**Consultation Response from KC,  
Trees**

**2024/92081 land adj, 36, Oxford Road, Dewsbury, WF13 4LL**

**Discharge of details reserved by conditions 3 (Remediation Strategy), 5 (CEMP:Biodiversity), 6 (CEMP), 7 (Arboricultural Method Statement), 8 (highway condition survey), 9 (Drainage strategy), 10 (Temporary drainage), 11 (BEMP) and 15 (oil / petrol inteceptor) of previous permission 2023/92712 for erection of 40 bed care home and 12 independent supported living units (use class C2) with associated works including the formation of car park and service access**

**Date Responded: 26/07/2024**

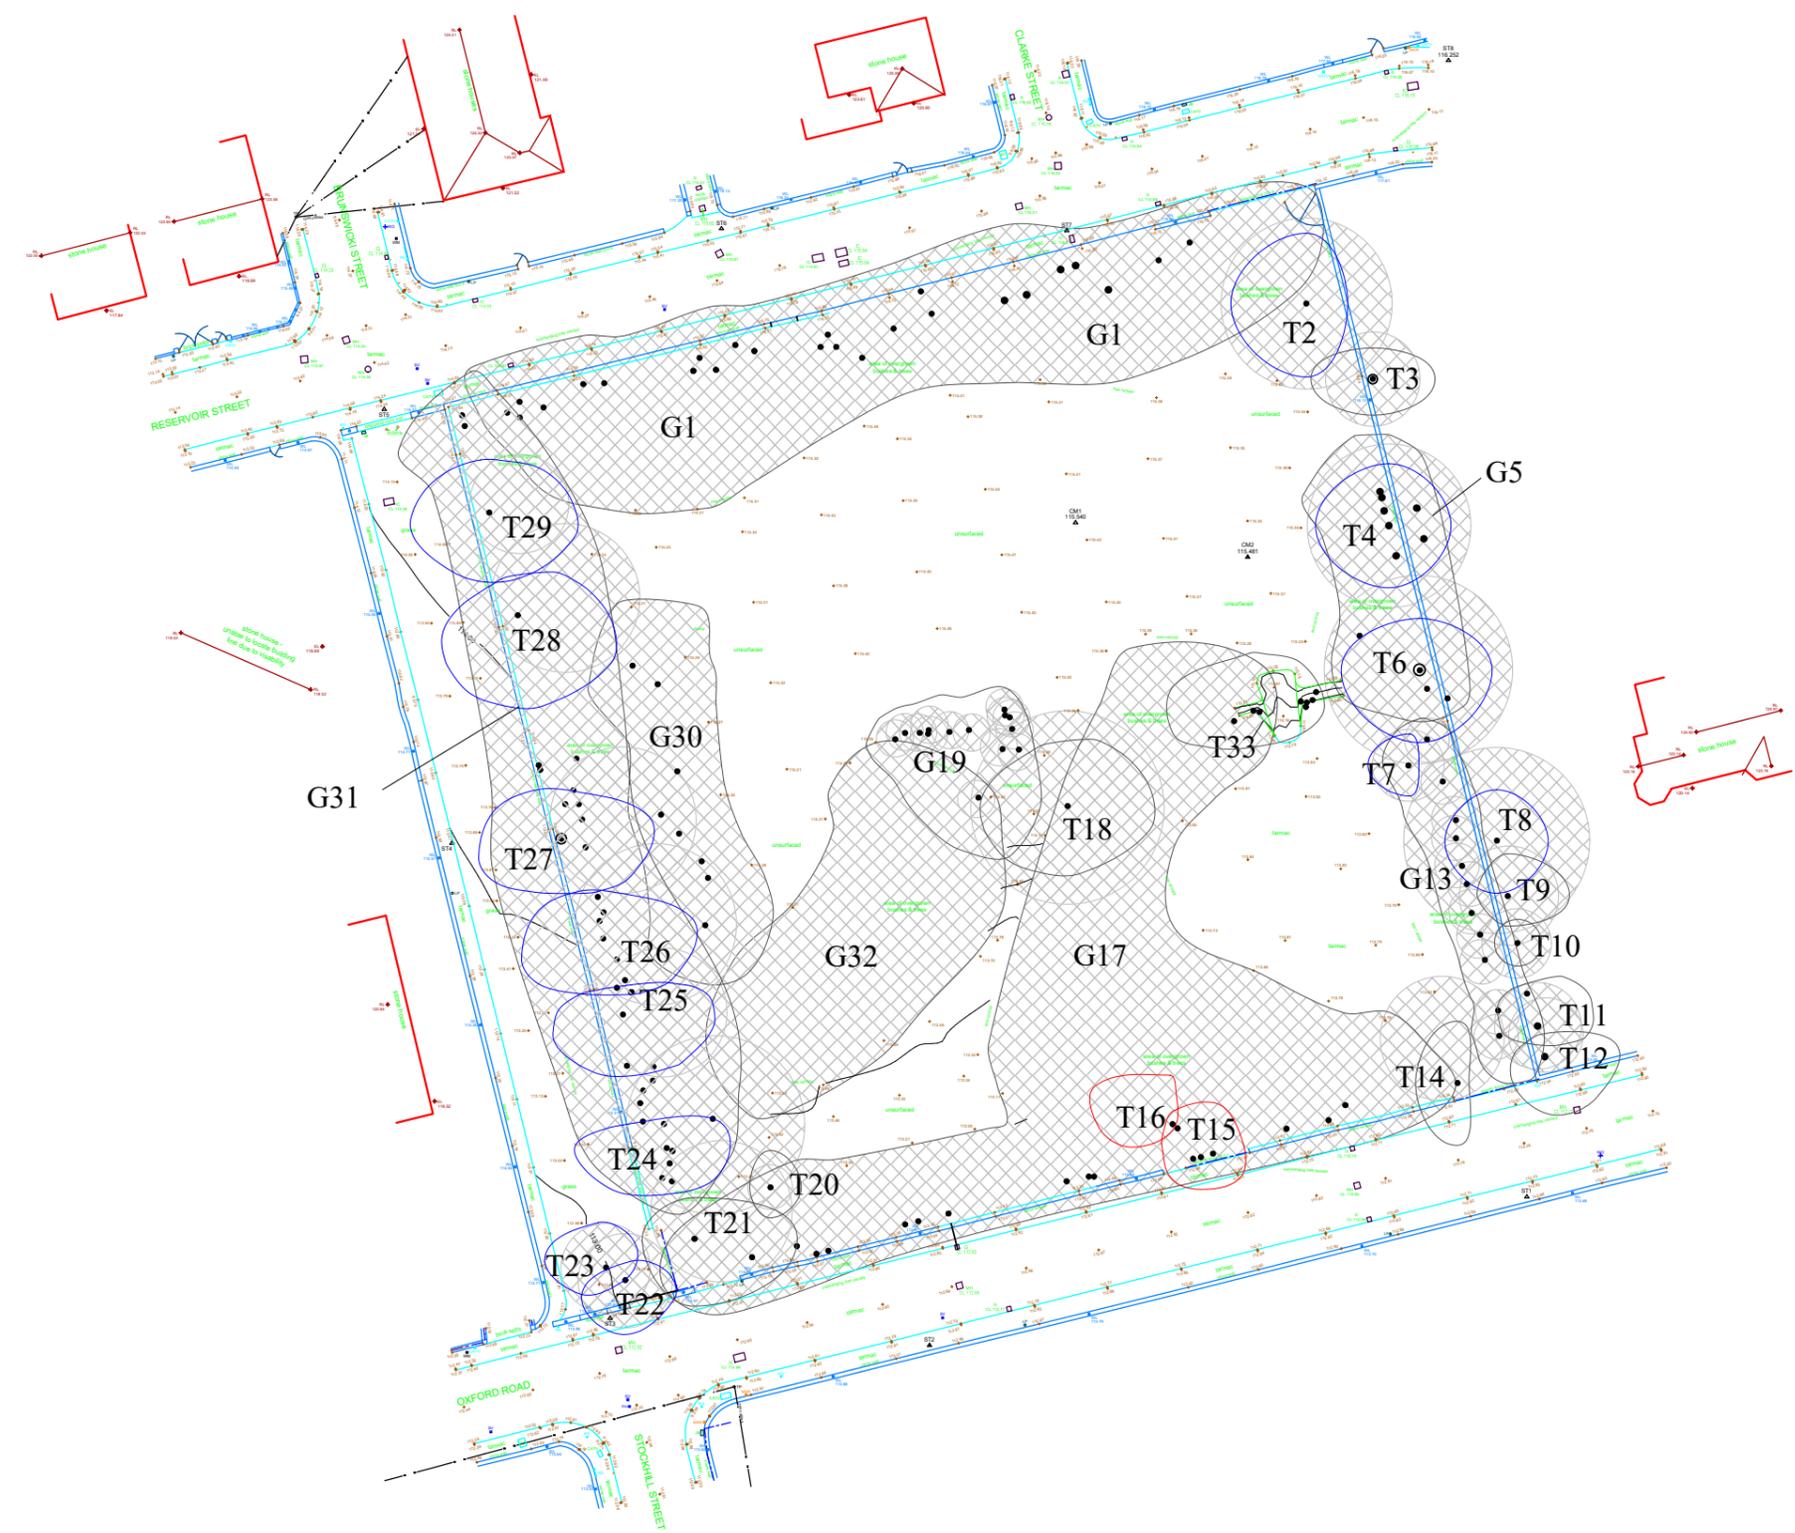
The submitted Arboricultural Method statement details how the majority of retained trees on site will be protected. The incroachment into the RPA's of T26, T27, T28 and T29 is still of concern however providing the special engineering required is done under the supervision of the project arboriculturalist I believe the impact on the roots could be minimized.

No objection.
